## Application for a Non-Material Amendment Following a Grant of Planning Permission

Carter Plantation Farm

ERECTION OF AGRICULTURAL WORKERS DWELLING

2022/62/90206/W

title **General Arrangement - as proposed**
number **21086D-02-P05**
scale **1:50 and 1:100**
size **A1**

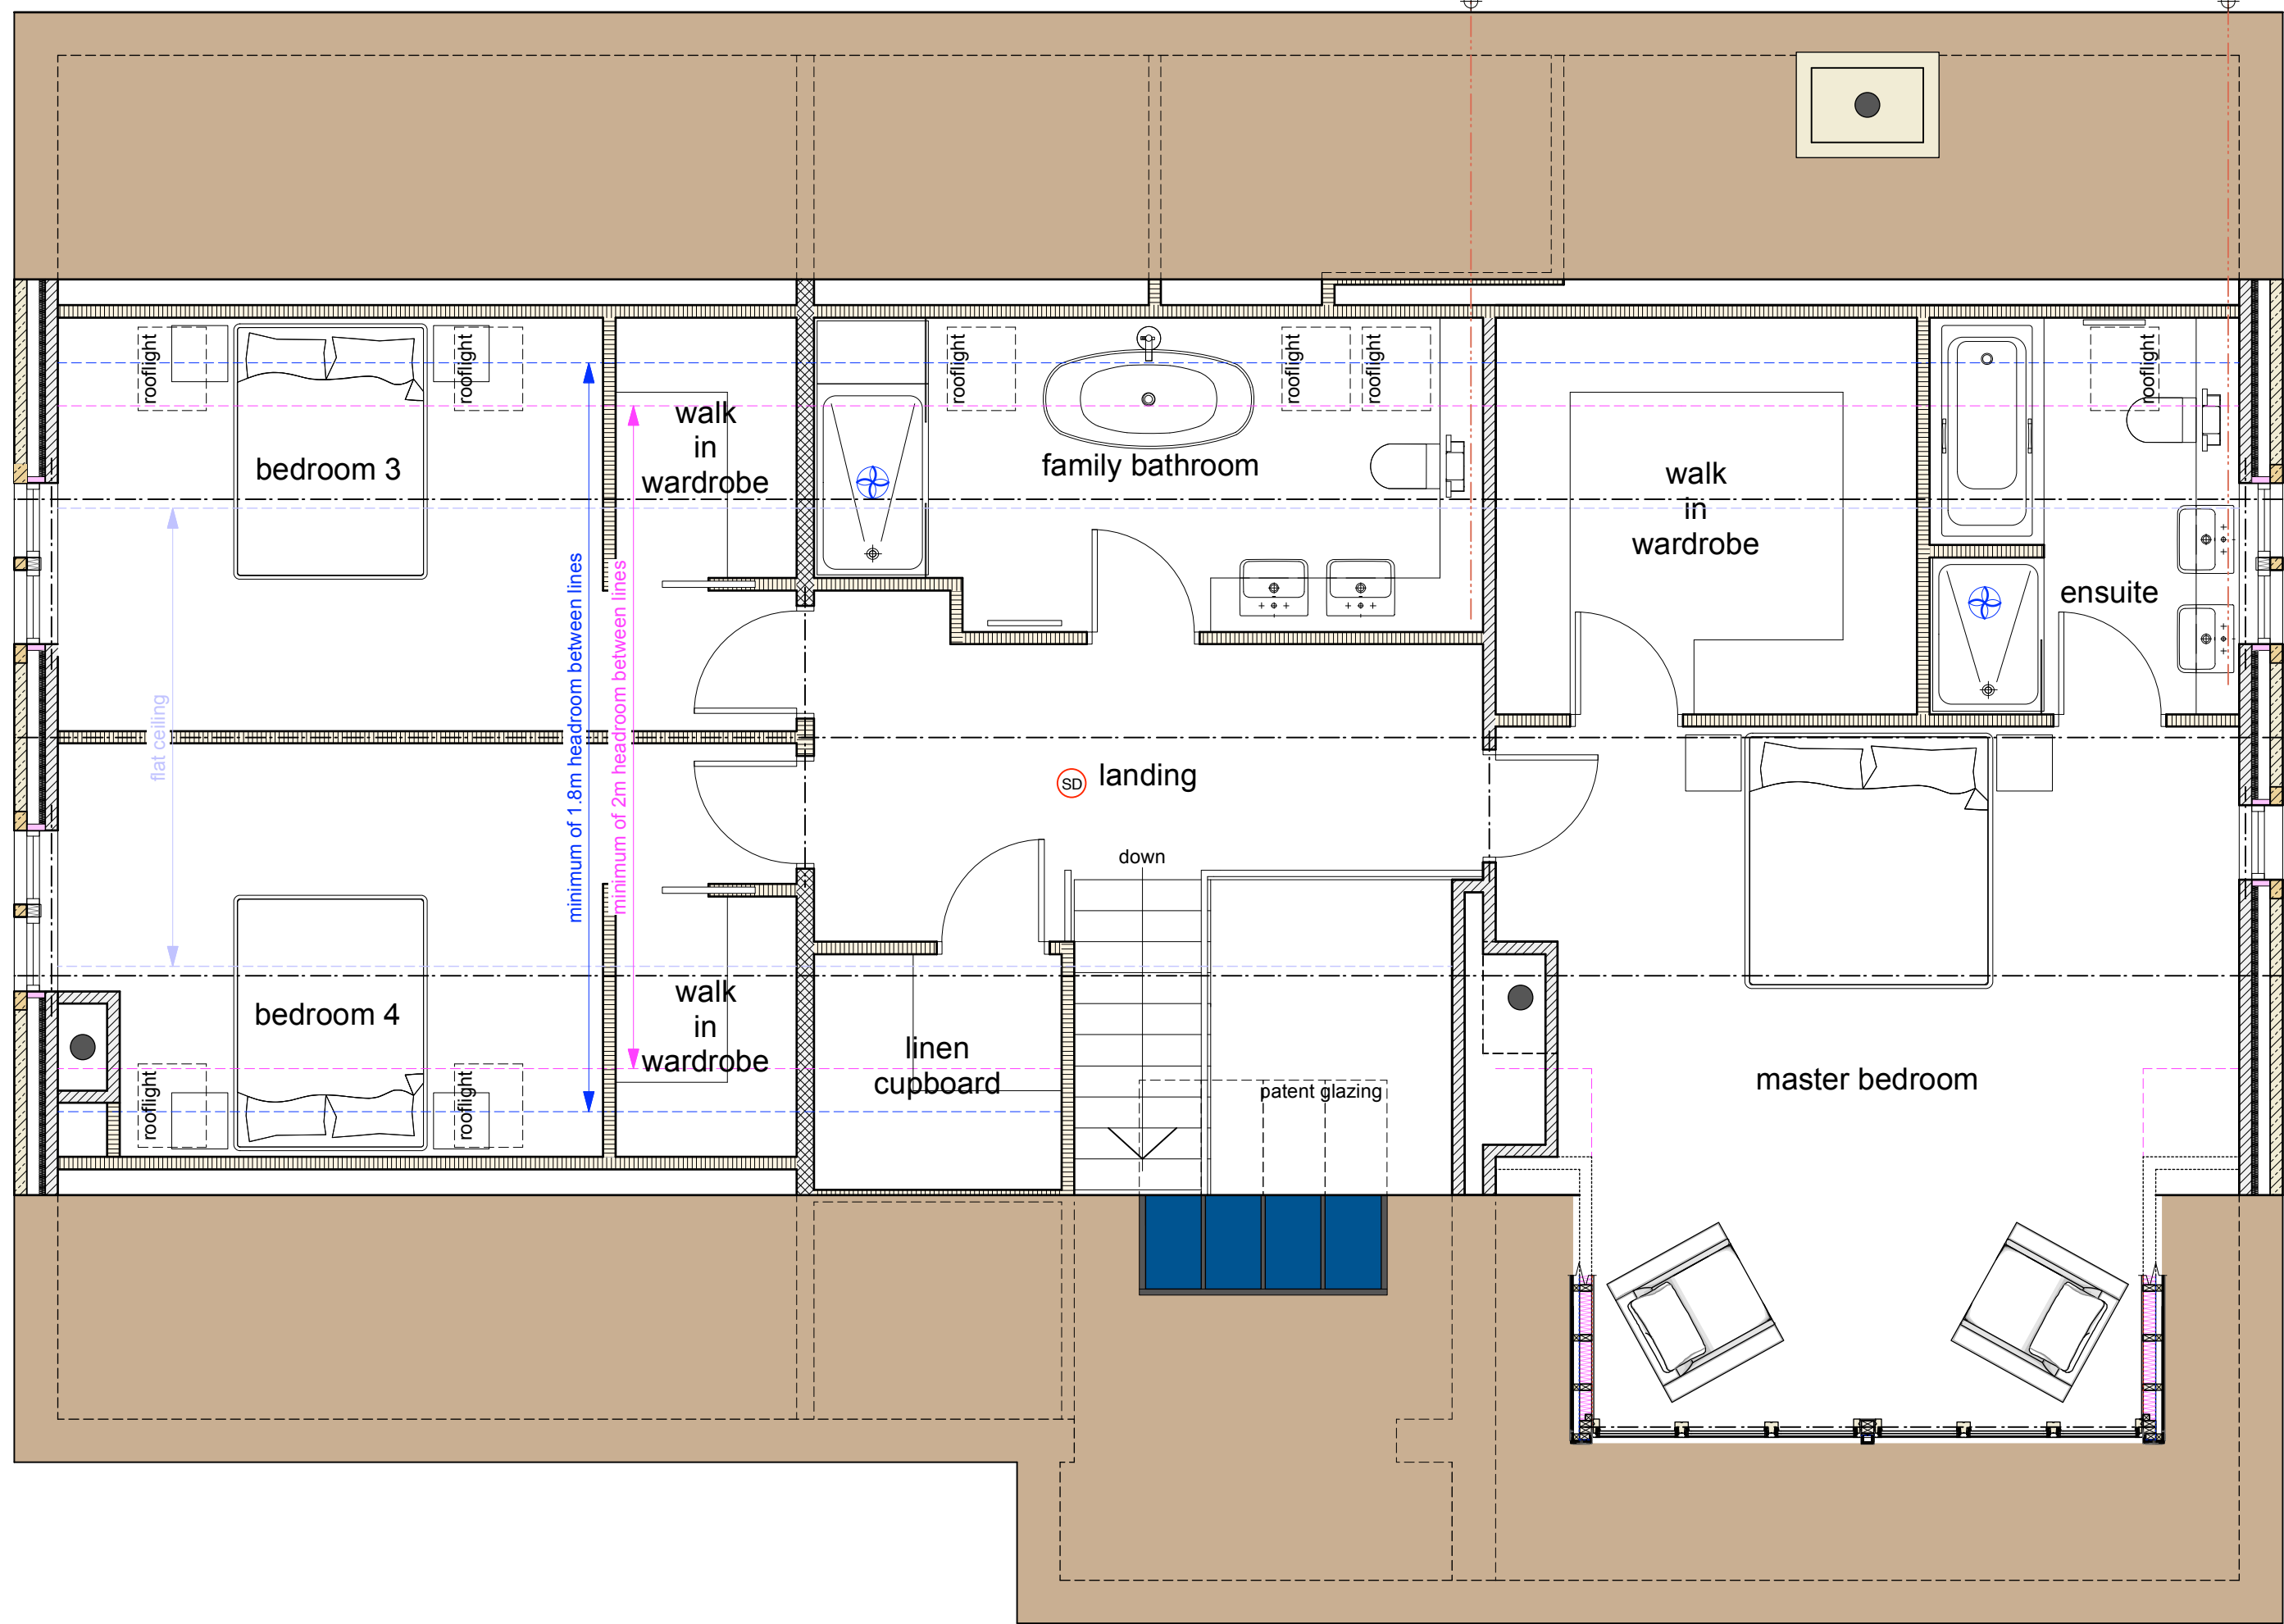
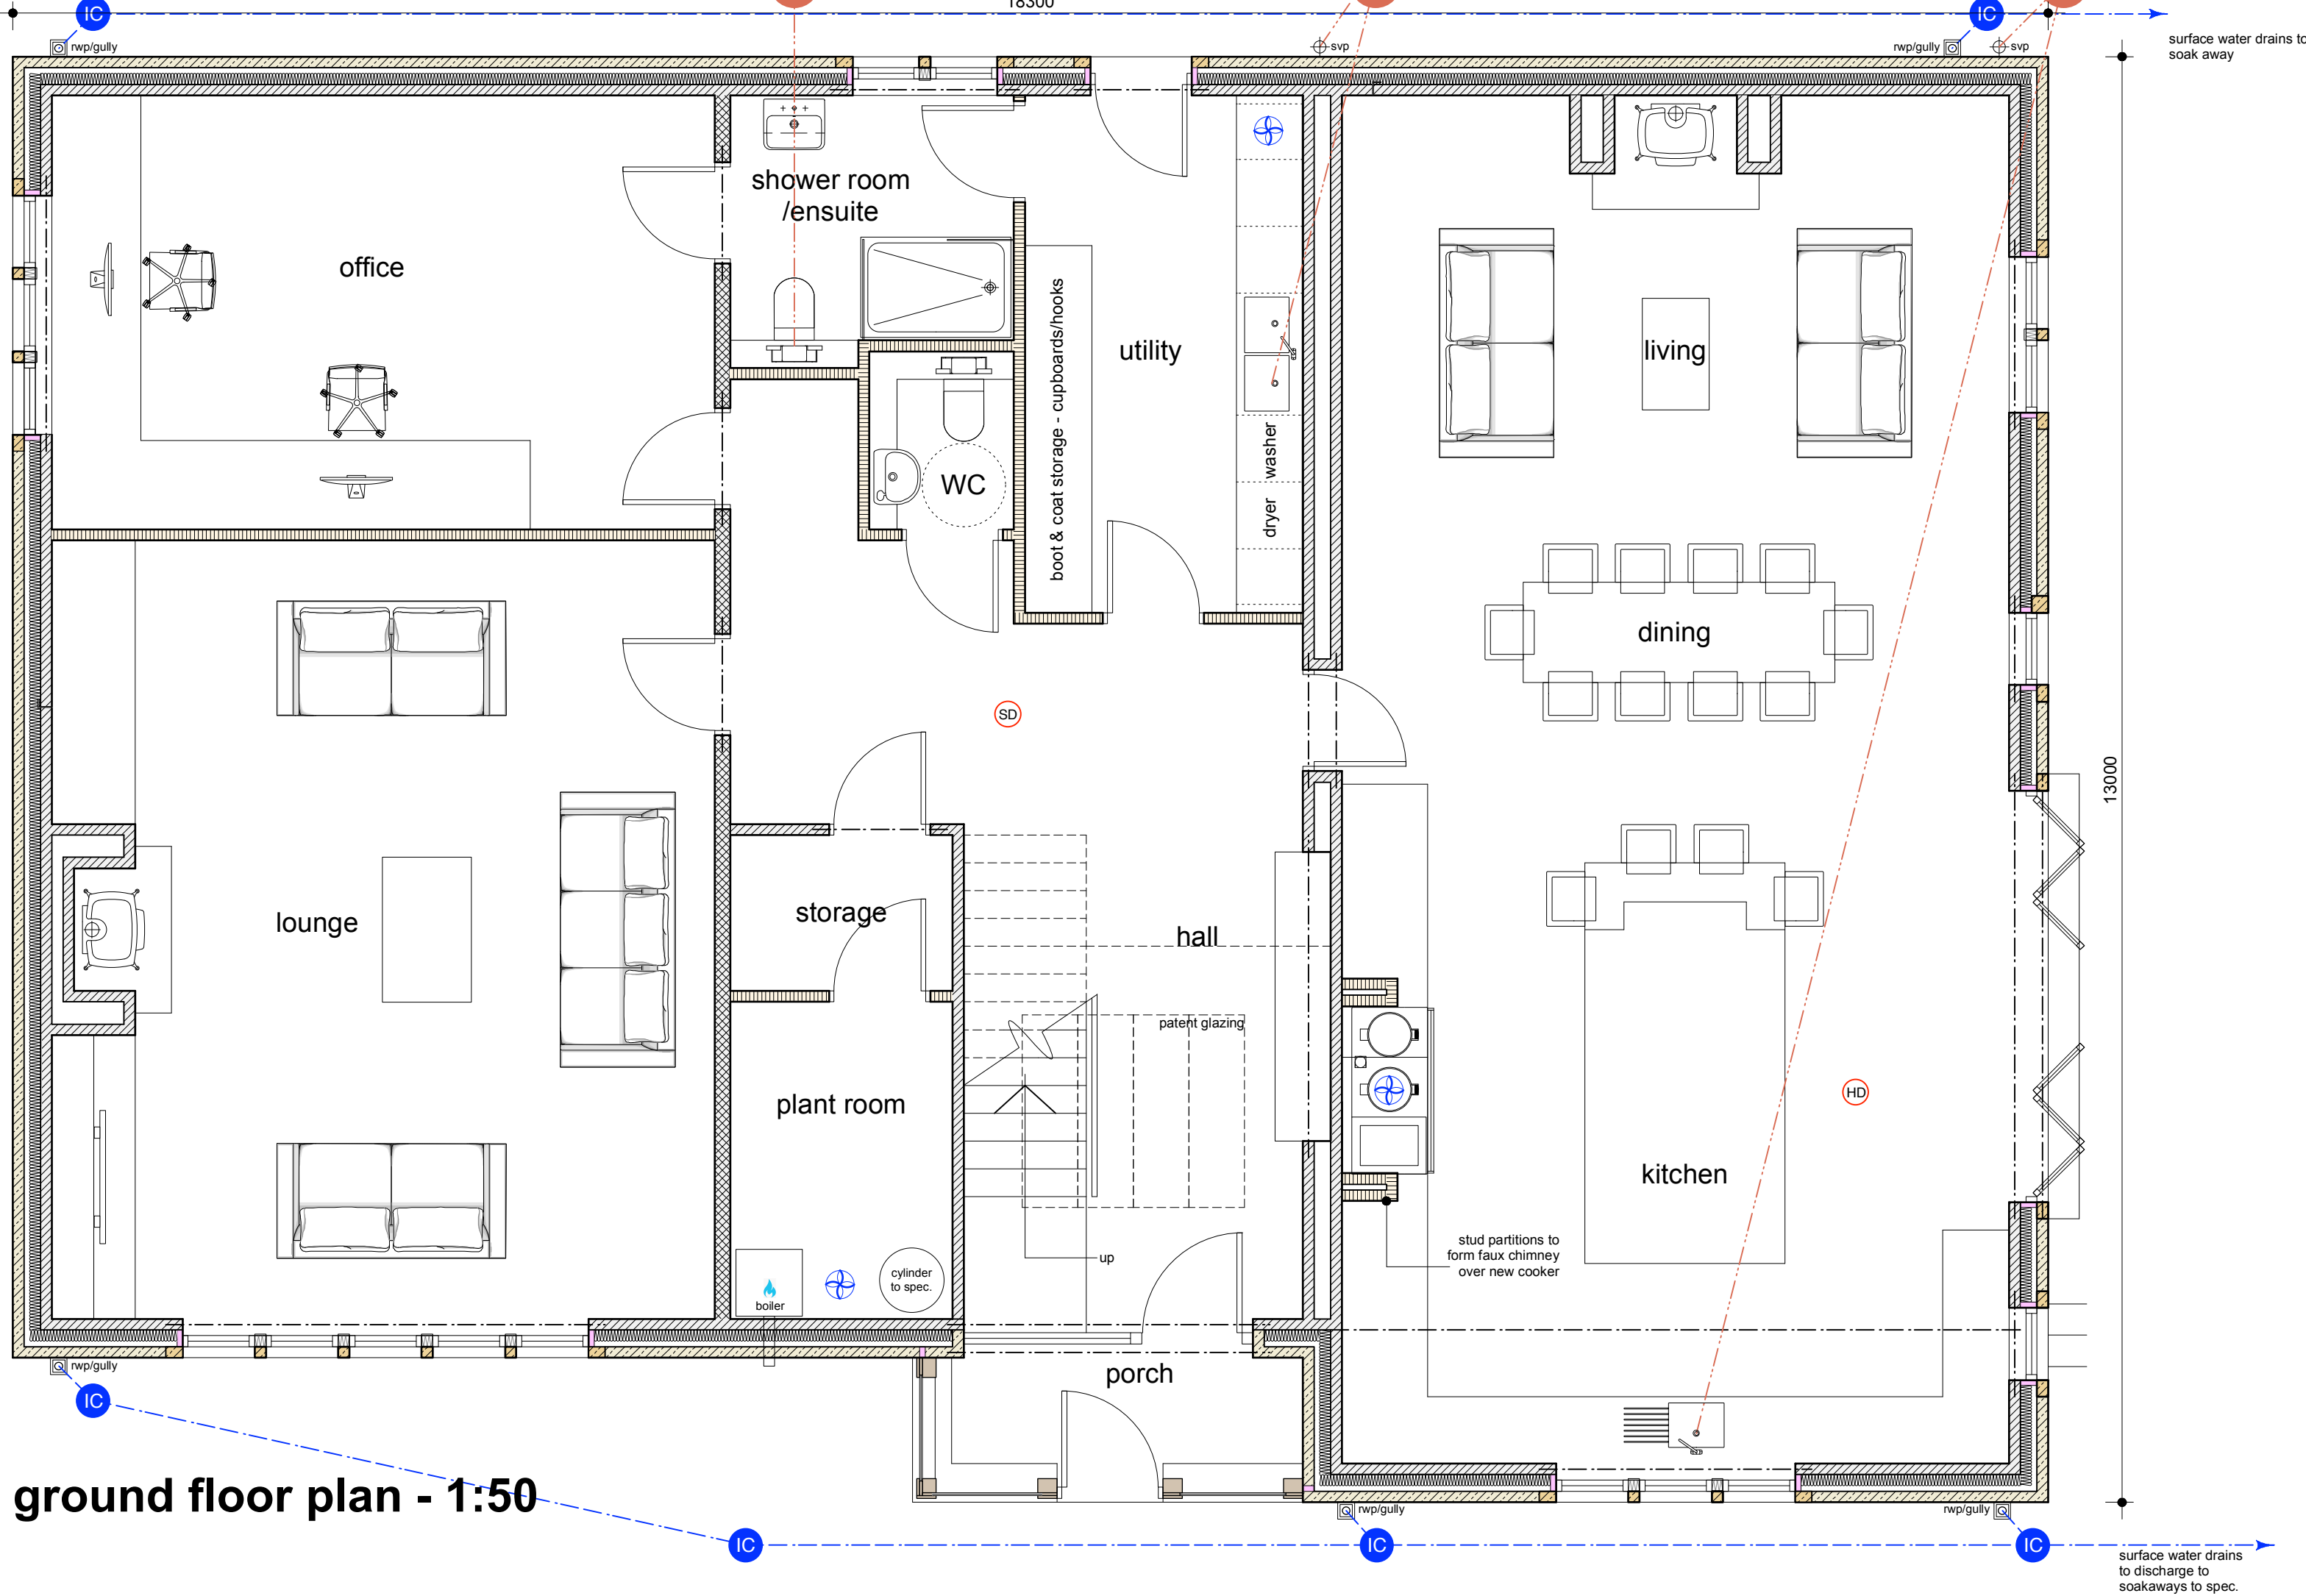
Change to internal layout which has amended the elevations as follows:

front elevation (east) - 1:100

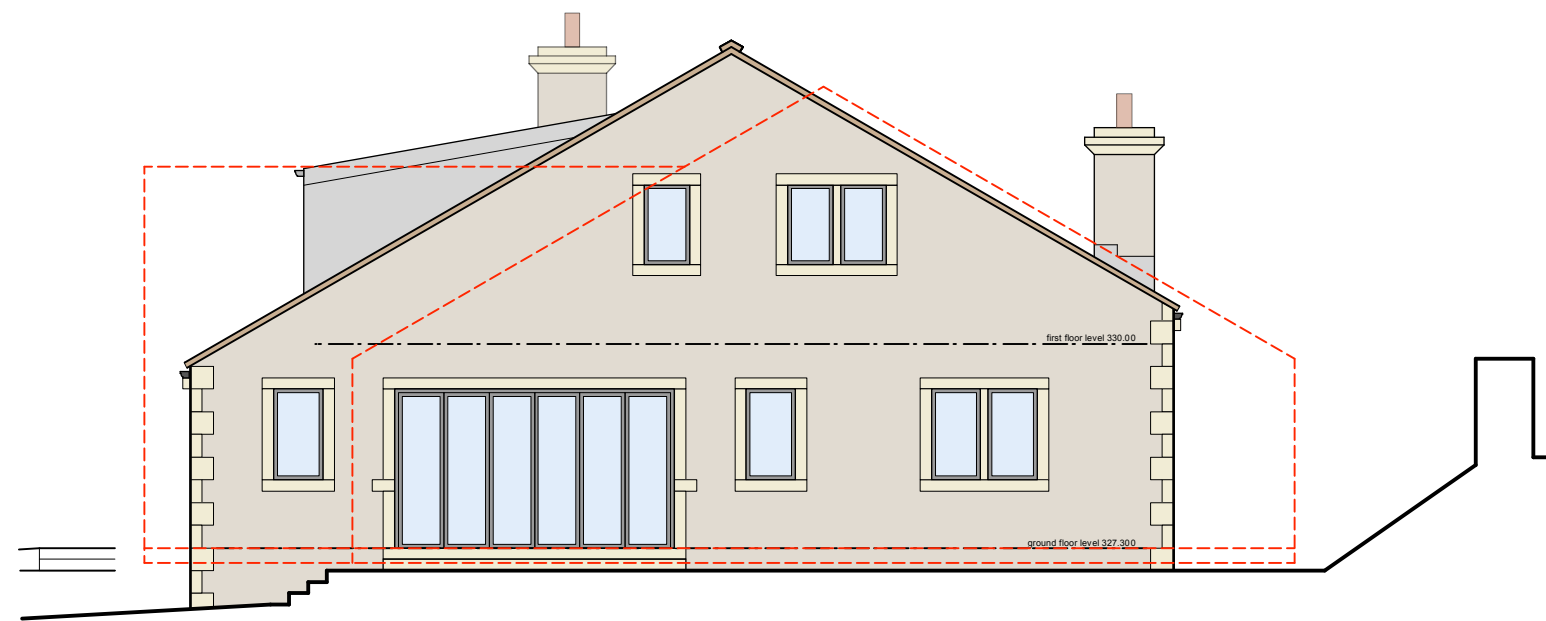
East elevation - additional chimney

rear elevation (west) - 1:100

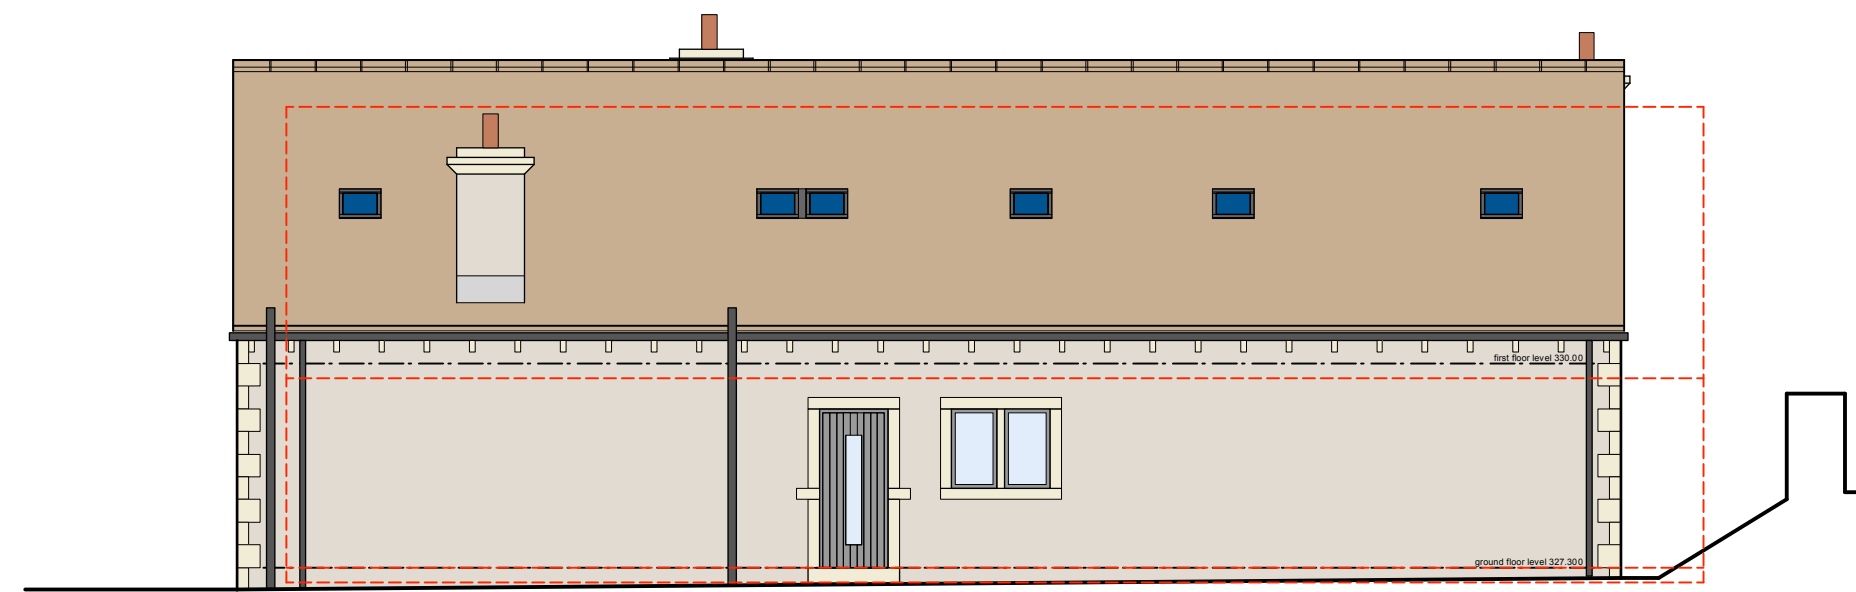
West elevation - reposition door, window & chimney

side elevation (south) - 1:100

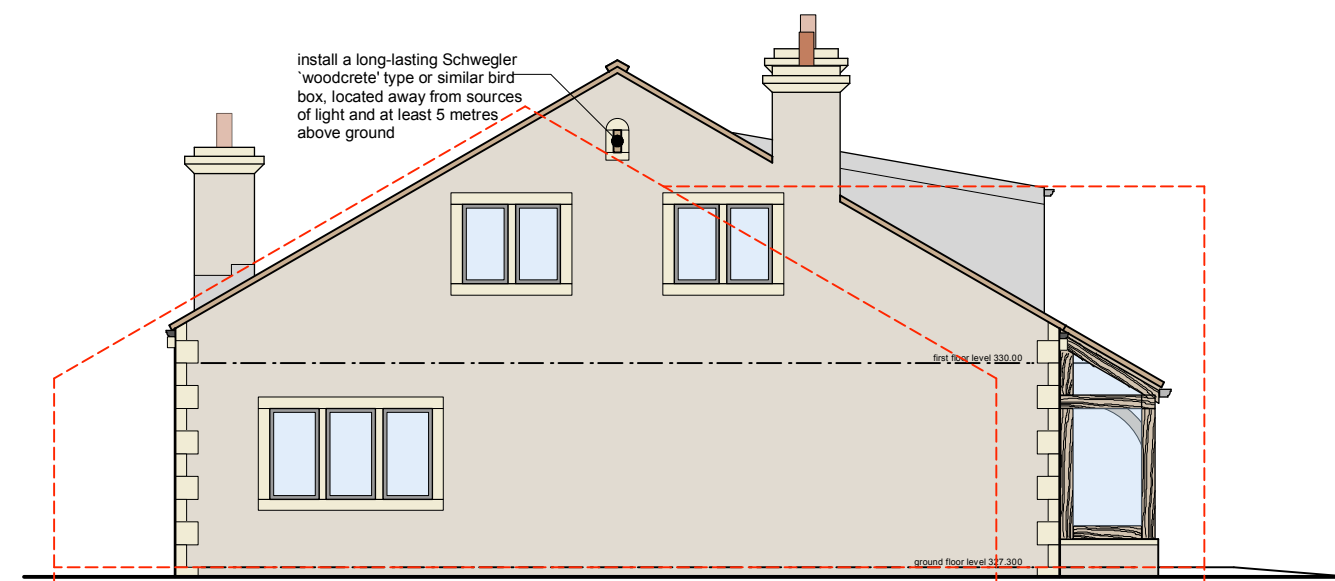
South elevation - reduce width of window, additional chimney (visible here)
